The Drovers Solar Farm

Applicant's Response to Deadline 3 Submissions

Document reference: APP/8.21 (Original)

Drawing file: published-documents / EN0110013-000144-6.3 ES Figure 12.13 Work No.2 Piling Locations within CSA for Maximum Groundwater Level.pdf

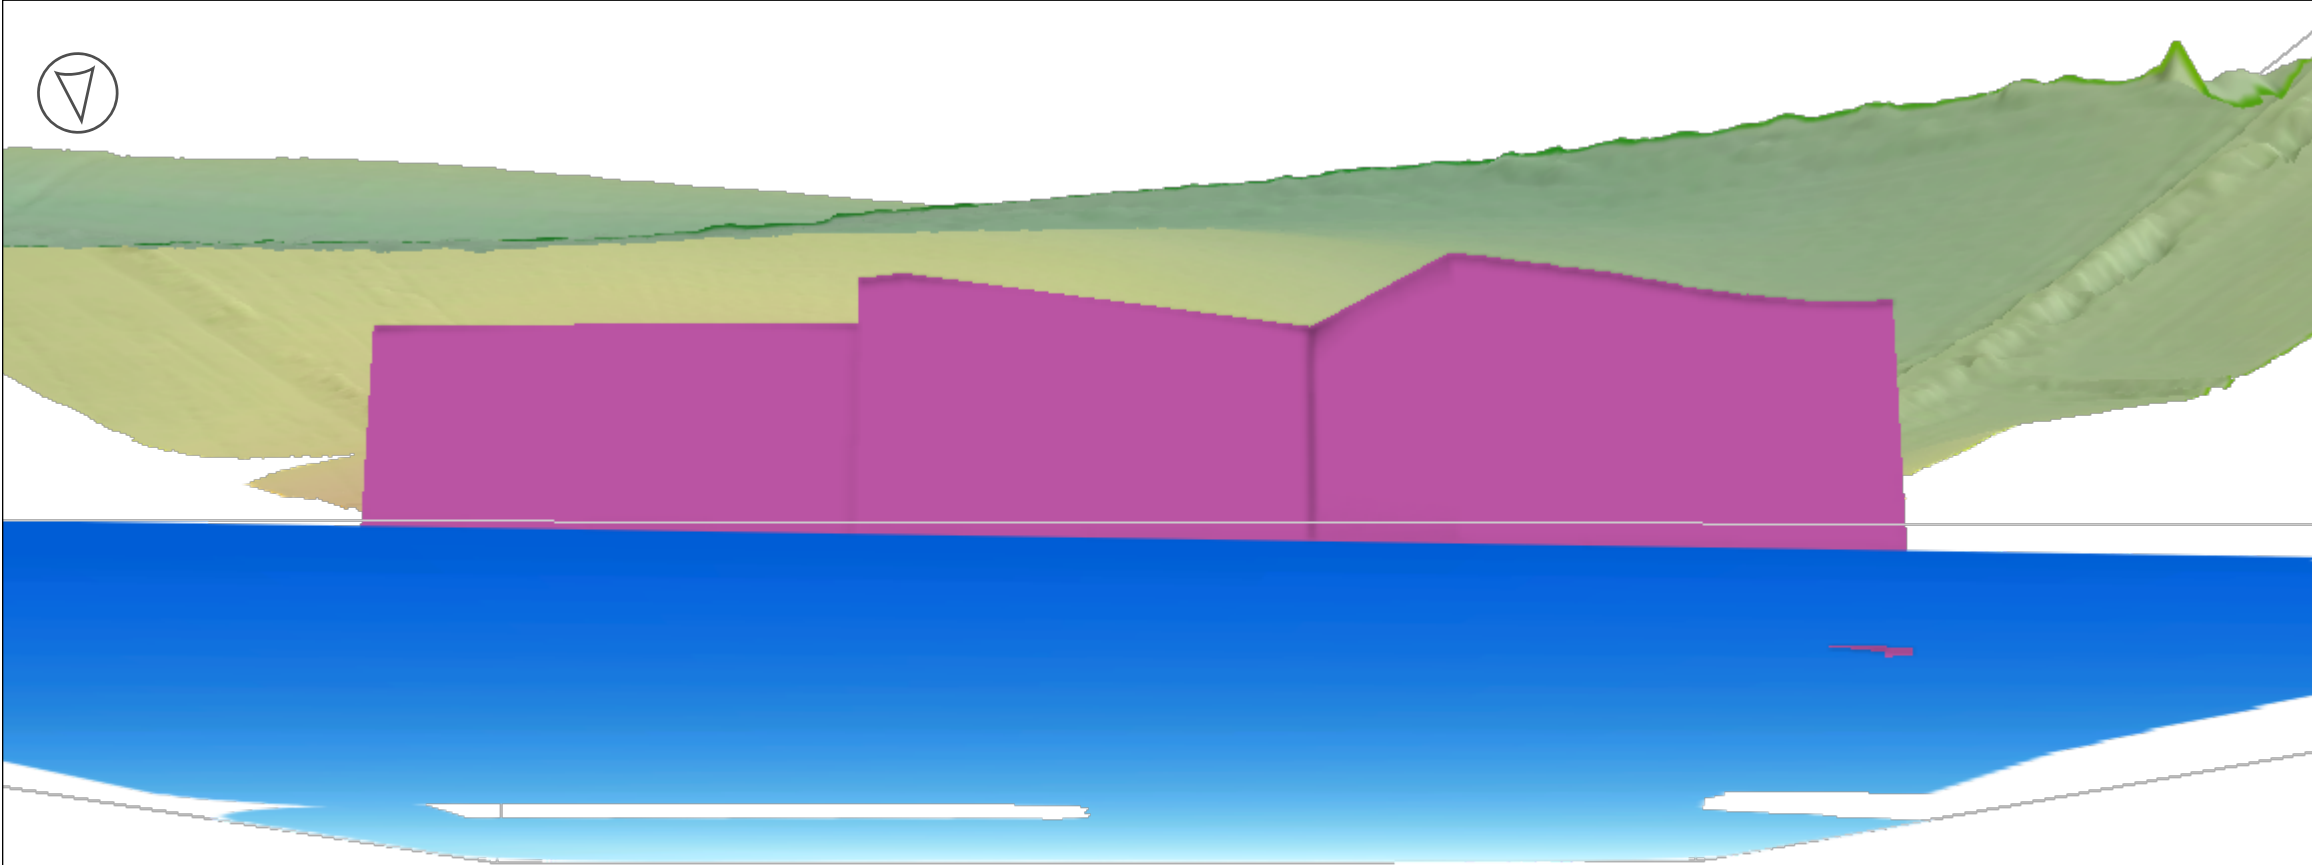
EA2-4	EA04 (Groundwater Flow Direction) We were concerned that the groundwater flow direction shown in figures 12.7 to 12.16 may be inaccurate. We advised that the claims made in sections 12.6.37 and 12.6.38 of 6.2 Environmental Statement Chapter 12: Water Resources [APP-061] should be revised, supported by new evidence. We are unable to find any amended figures in the updated documents.	Figures associated with ES Chapter 12: Water Resources [APP/6.2.3] were updated at Deadline 3 to reflect the EA's comments. This matter is now agreed with the EA, per the EA's Deadline 3 Submissions Follow-up Response Letter [AS-088] .
EA2-5	EA05 (Maximum Foundation Extents) We were concerned that figures 12.13 [APP-127], 12.14 [APP-128], 12.15 [APP-129] and 12.16 [APP-130] do not clearly define the area represented by the drawings, including view orientation, or the elevation values. We are unable to find any amended figures in the updated documents. We note that figure A12-1-10 provided in the 6.4.2 Appendix 12.2 Flood Risk Assessment (Tracked) [REP2-019], appears to show no interaction between any of the Work Nos to a depth of 15m. This contradicts the statement in 6.2.1 Chapter 12 Water Resources (Tracked) [REP2-011] Section 12.8.20, which states that a potential interaction of up to 1m has been determined for a small section of Work No. 4.	Figures associated with ES Chapter 12: Water Resources [APP/6.2.3] were updated at Deadline 3 to reflect the EA's comments. It should be noted that there is a very minor area of interaction between Work No. 4 and the maximal groundwater elevation, which may not be perceptible at the scale produced within Plate 12-22 of ES Appendix 12.2 Flood Risk Assessment [APP/6.4.4]. As such, there is no contradiction between the two documents referenced. This matter is now agreed with the EA, per the EA's Deadline 3 Submissions Response Letter [AS-087].
